From: Tim Murray <[REDACTED]>
Sent: 21 October 2021 15:43
To: Kathryn Welch
Subject: RE: 6 St Mary's Close Littlehampton
Attachments: St Mary's Close 6-PLANNING.pdf

DRAWING	SCALE
PLANNING	1/100
DATE: AUGUST 2021	
DRAWN: T. Murray	
DRAWING: 21/64/3	REVISION:

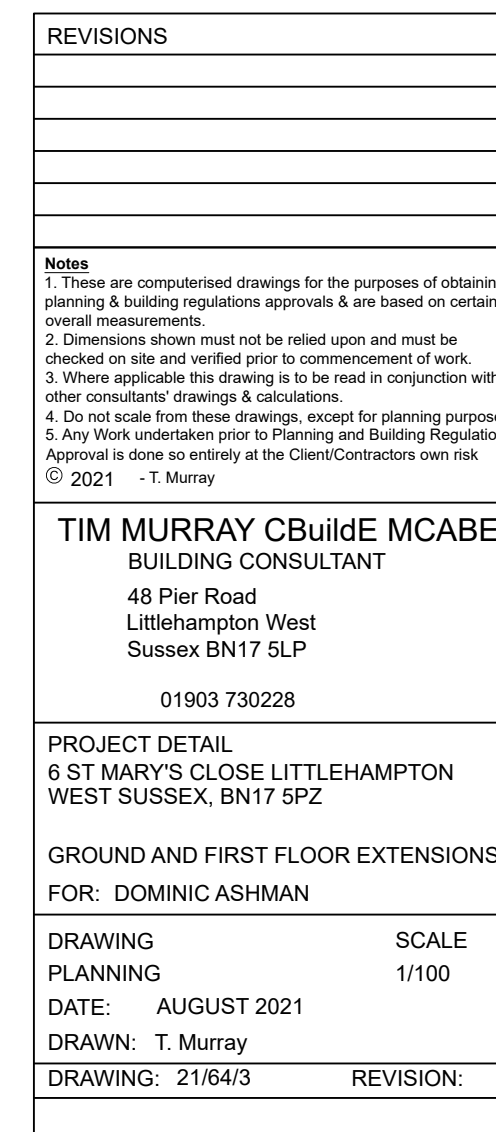
I think that's the original plan again, I can see no alteration to the dormer windows position as discussed.
